From: Craig Shinkin <Craig@wellandidb.org.uk>
Sent: 02 July 2026 11:10
To: Niland, Mark
Cc: _planningadvice; HighwaysSUDsSupport; Jane Picking
Subject: H16-0552-26 (CS/JP/P/S/7 - Full) - Land off Shakespeare Way, Holland Park, Spalding, PE11 1GU

Planning Application: H16-0552-26 (Full – Erection of a 3-storey care home development with associated car parking, amenity space and ancillary structures)

102378-DCE-XX-XX-DR-C-5000

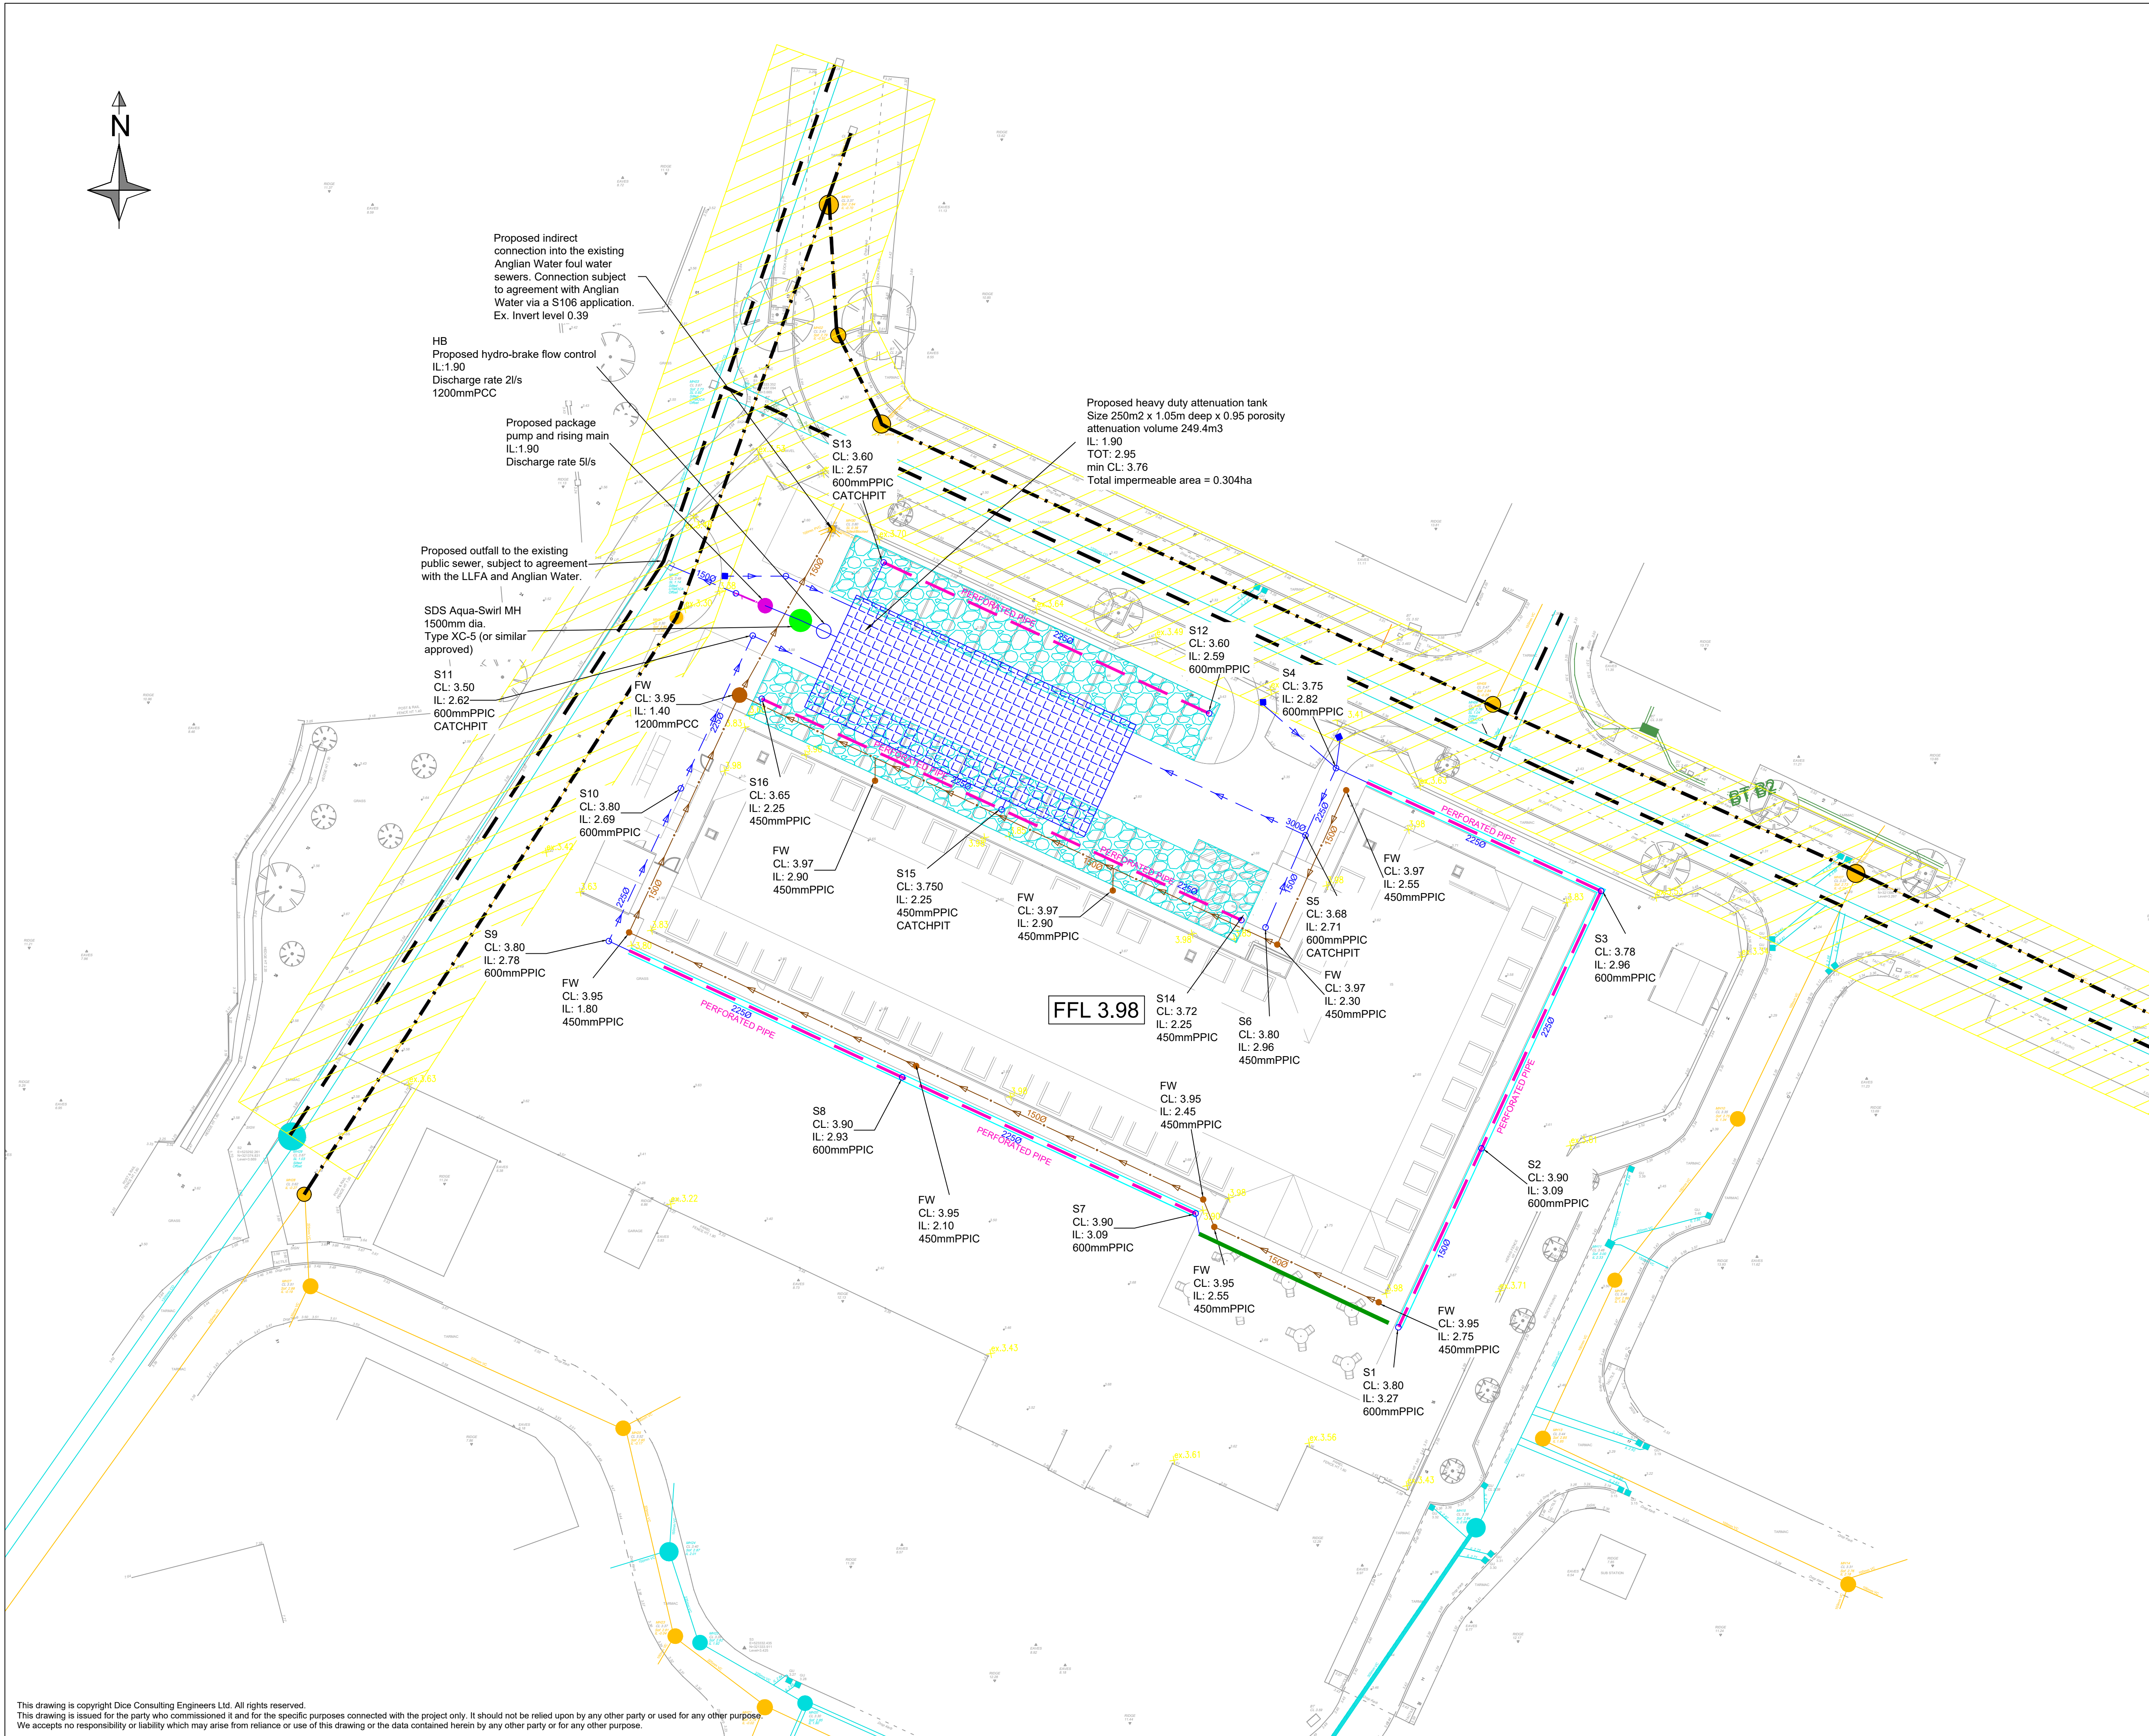
I am pleased to see that discharge flows from the site are being restricted to 2 litres/second as detailed on Proposed Surface Water Drainage Plan reference: 102378-DCE-XX-XX-DR-C-5000, Revision P01 prepared by Dice Consulting Engineers Ltd dated 5th May 2026.

The proposed surface water discharge from the site requires the prior written consent of the Board should planning permission be granted. Any application is subject to the agreement of technical details, payment of the application fee as well as payment of the relevant development contribution. Based on a total impermeable area of 0.3 ha and a maximum flow restricted to 2 litres/second, this results in a development contribution of £7,592.94 payable in advance of connection. Please note that development contributions are subject to annual increase in line with RPI.
